DEVIATION REQUEST AND DECISION FORM

Project Name : **BENT GRASS EAST COMMERCIAL FILING NO. 3**
 Schedule No.(s) : 53011-01-060
 Legal Description : Tract BB, Bent Grass East Commercial Filing No. 2B

TRUCK TURNING EXHIBIT
(WB-40 INT. SEMI-TRAILER)

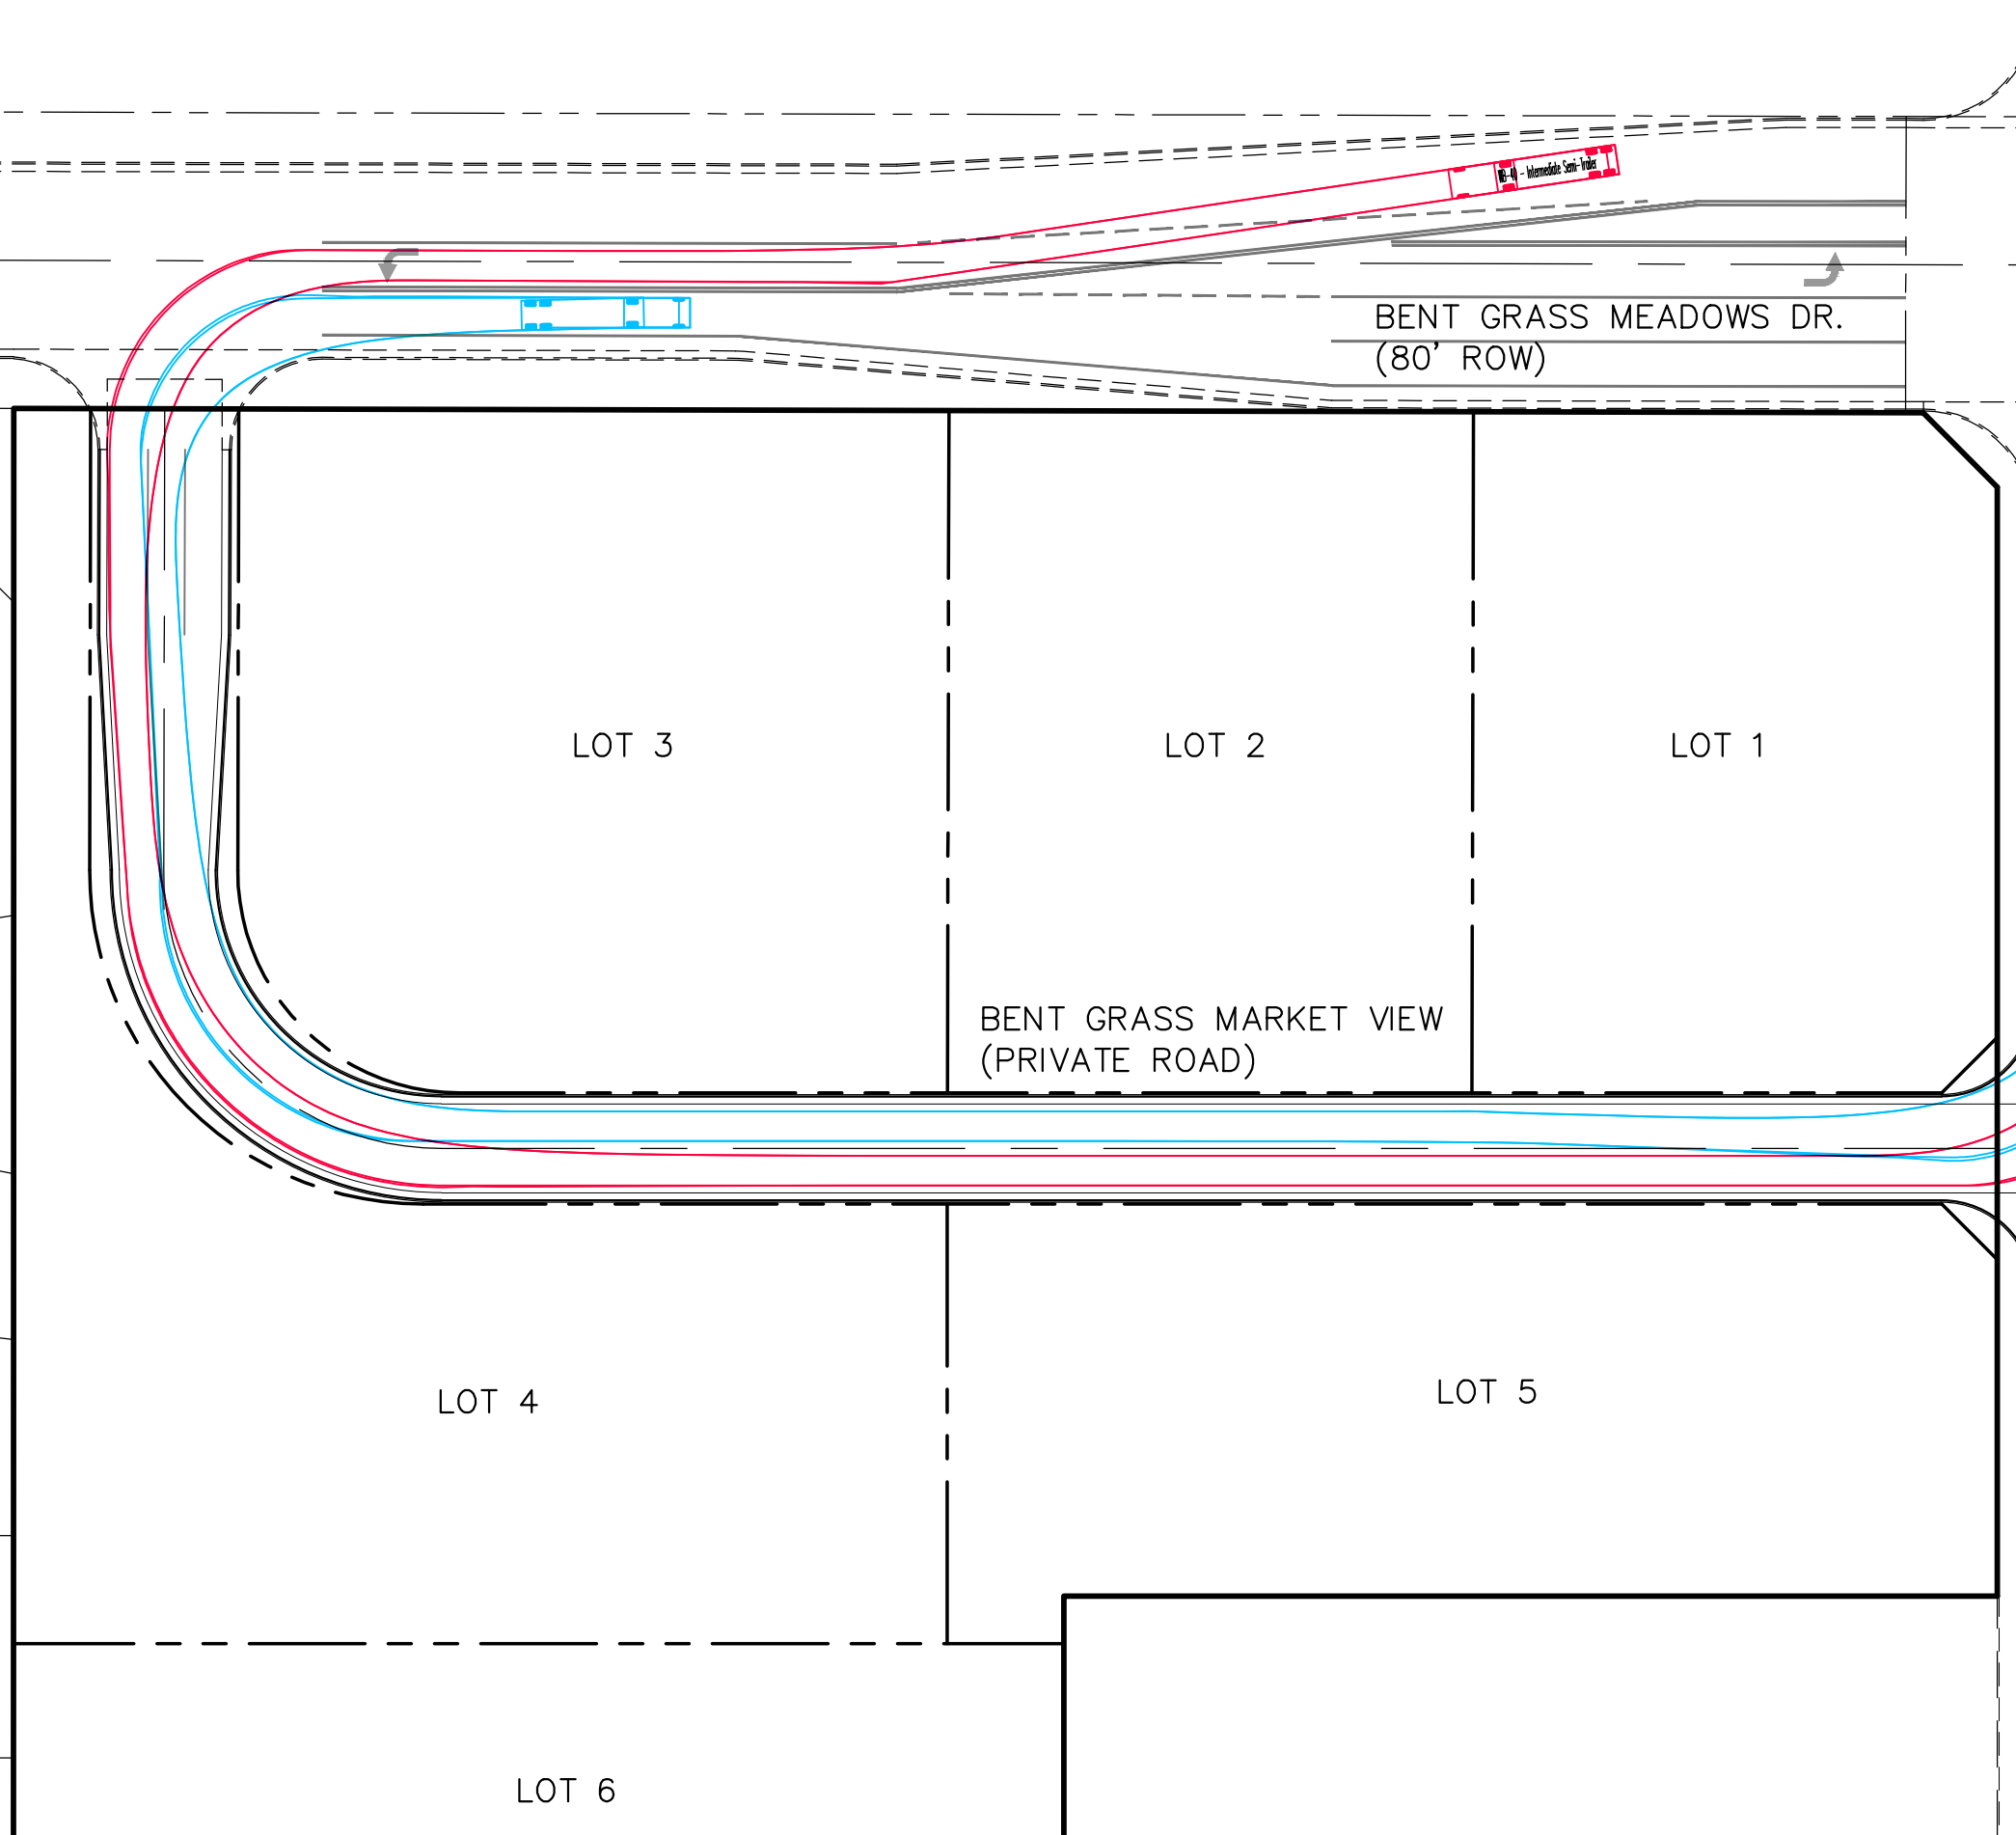
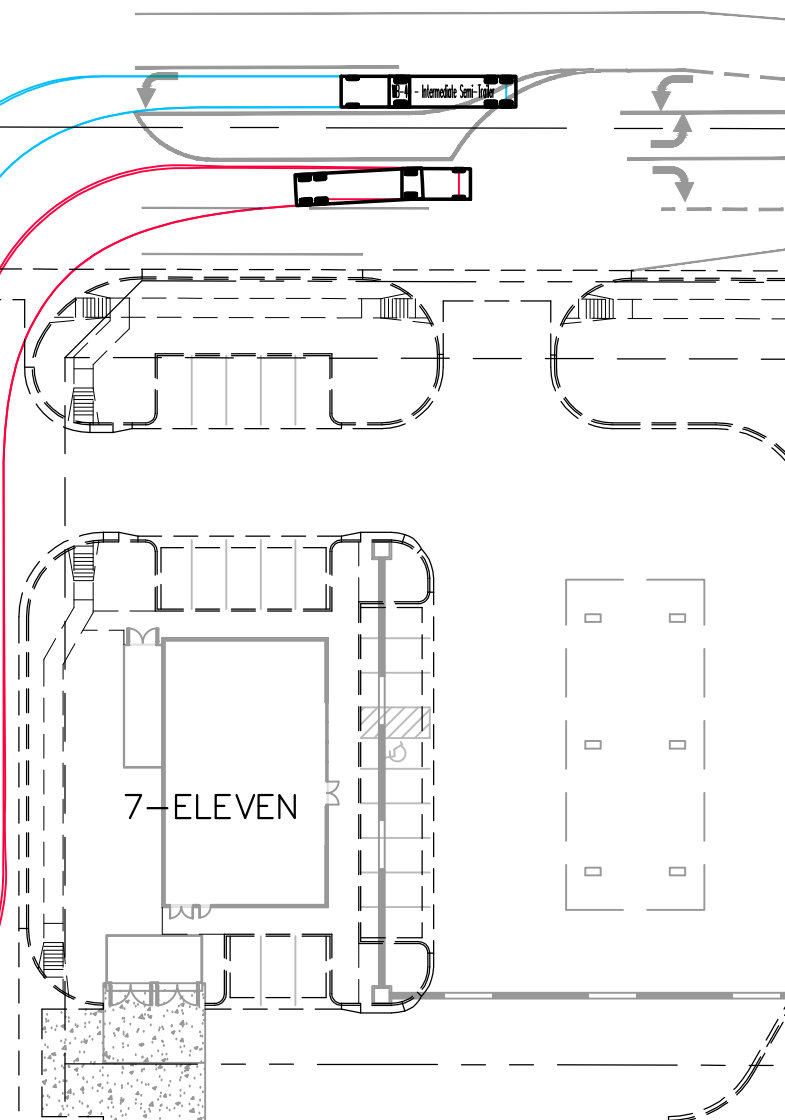
The radius proposed does not appear sufficient as the design vehicle encroaches onto opposing traffic. Please revise accordingly.

TYPICAL PRIVATE ROAD CROSS SECTION

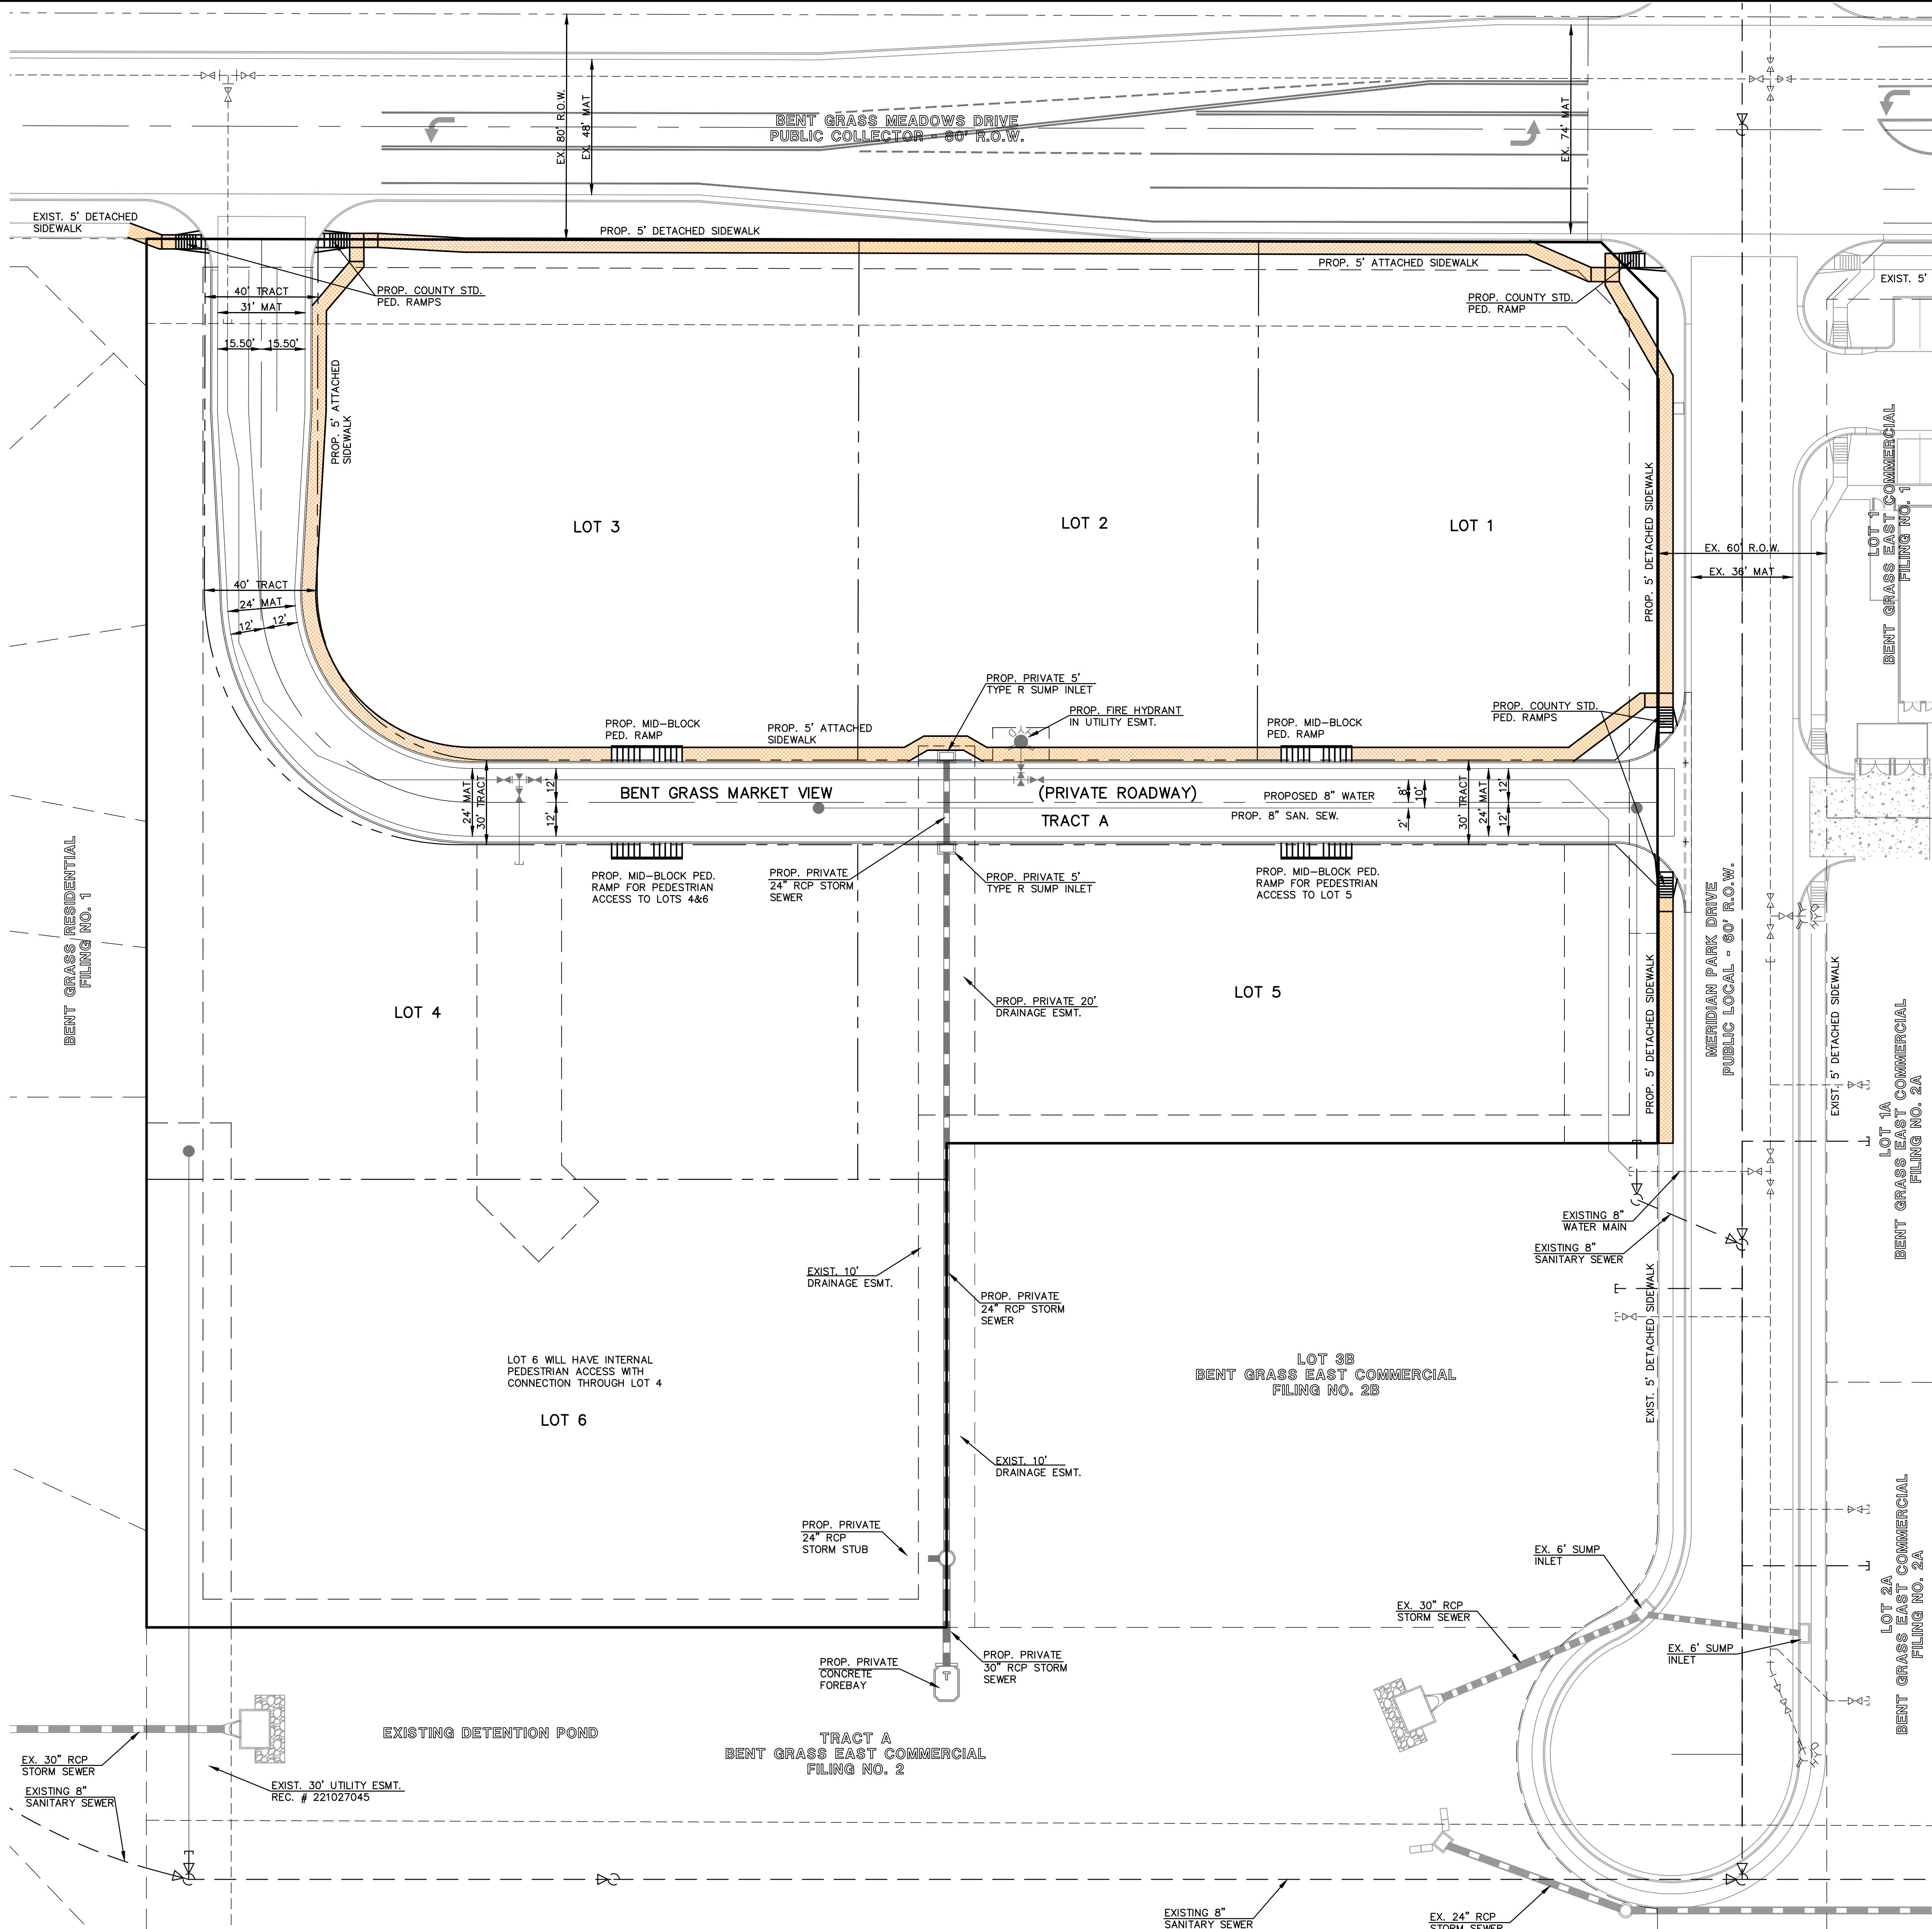
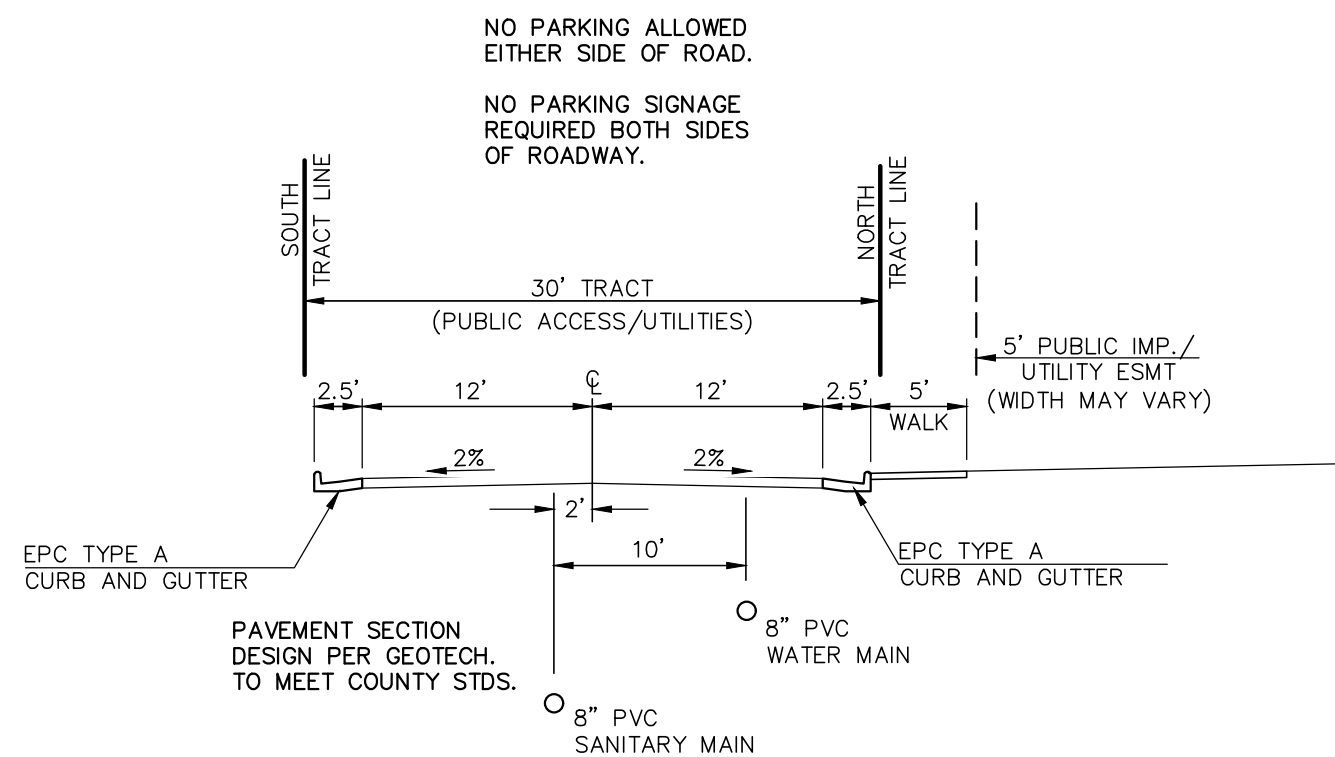
Although comments have been provided, the justification provided within this deviation is not sufficient at this time for the County to support a 24' cross section.

Adequate justification for the 24' width proposed has not been provided. The 24' width is not sufficient for the traffic generated. Based on the proposed uses, turn lanes may be required along this roadway and the proposed width does not provide sufficient space for future turn lanes. The ECM does provide adequate road sections for commercial developments such as this. The County can support a private road however it must meet standards for this volume of traffic.

Is the intent for the owners of lot 4 and 5 to construct the sidewalk for access between the two lots and their businesses? Please address.
